**Consultation Response from KC,
Highways Development Management**

2024/93080 Bath Works, Lamb Hey, Spa Lane, Linthwaite, Huddersfield, HD7 5QB

Formation of access, re-grading of land levels within the site and associated engineering operations

Job No. 21 J 24.	Drawing number 10 B.	Date Feb 2025.
---------------------	-------------------------	-------------------

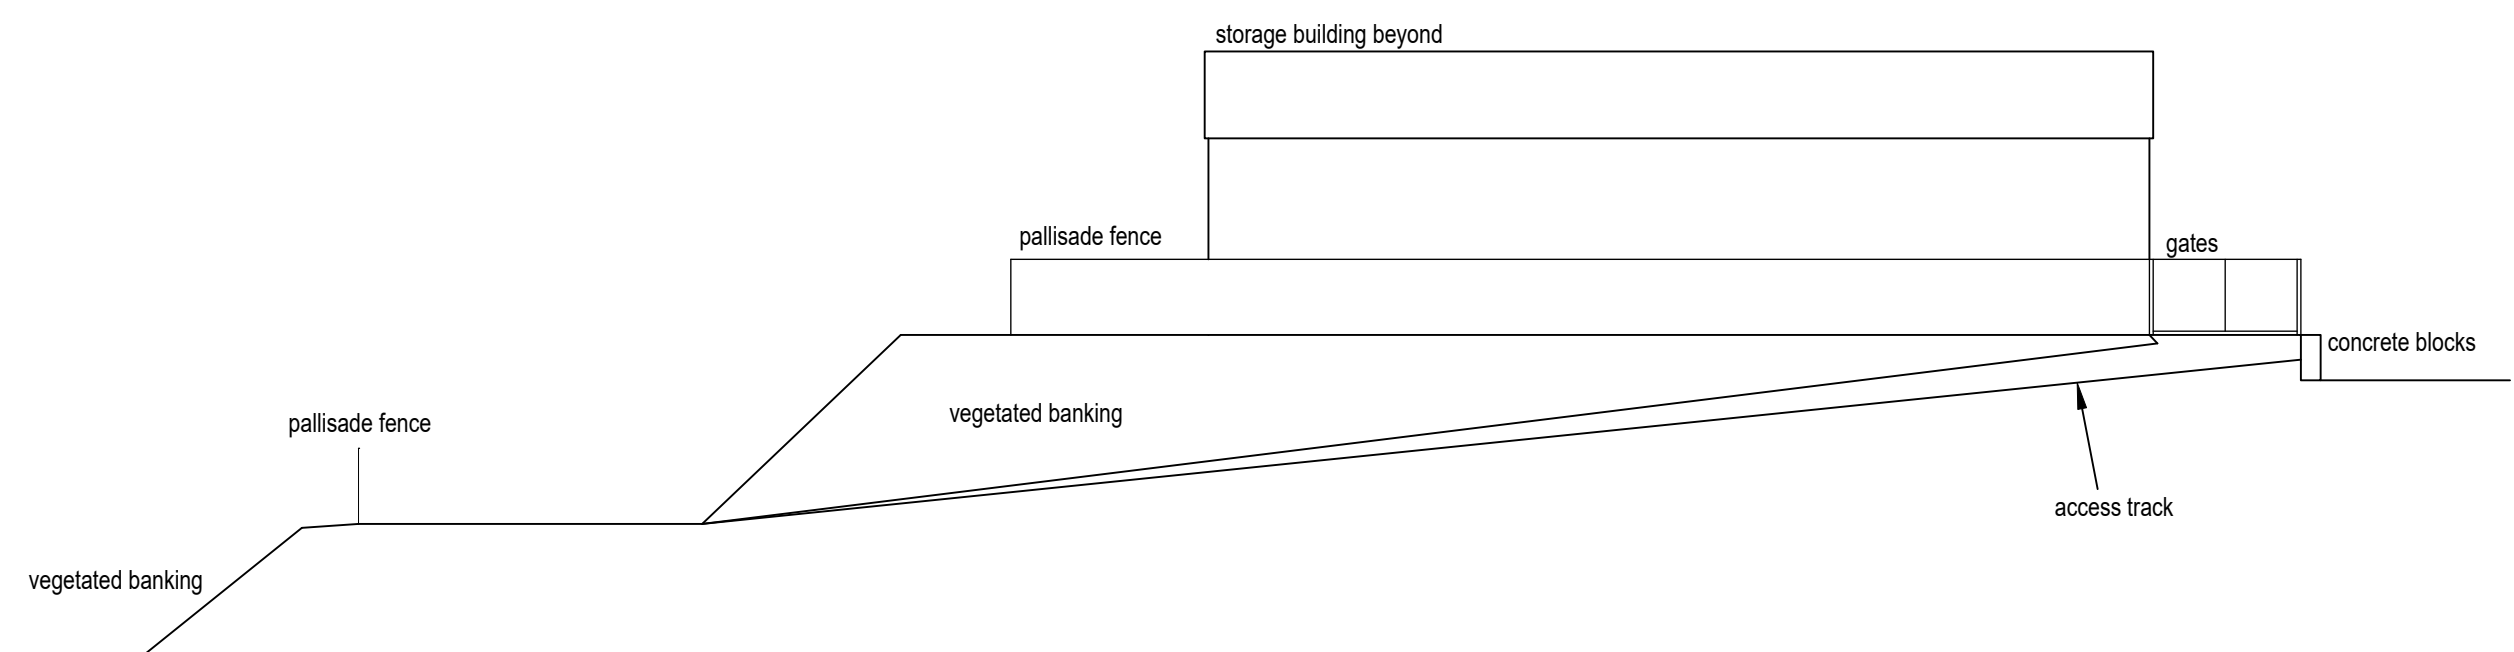
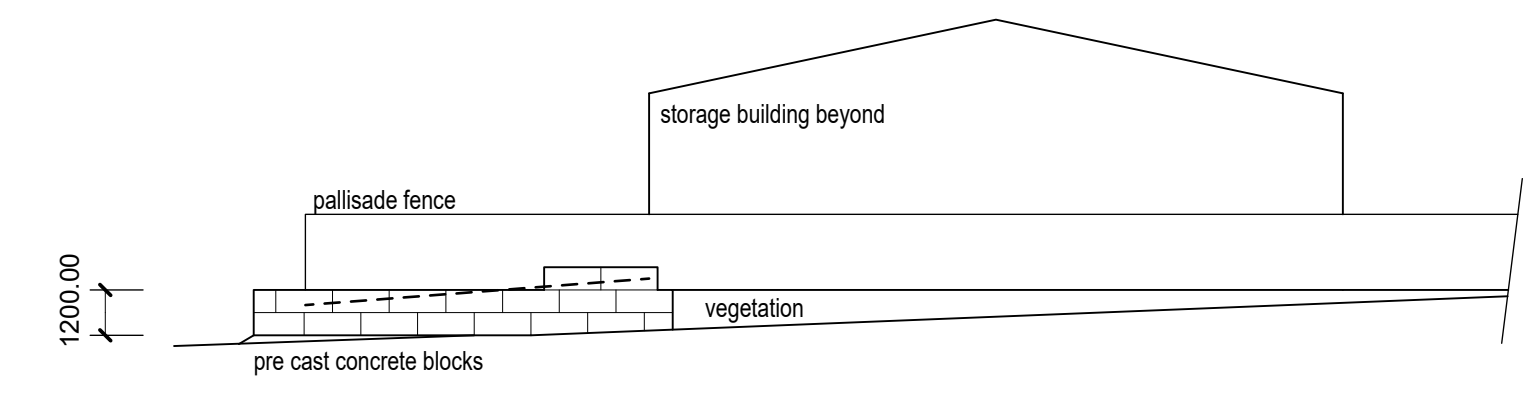
Revised plan 21 J 24 10A shows the height of precast concrete blocks adjacent to Spa Lane at 1.2m.
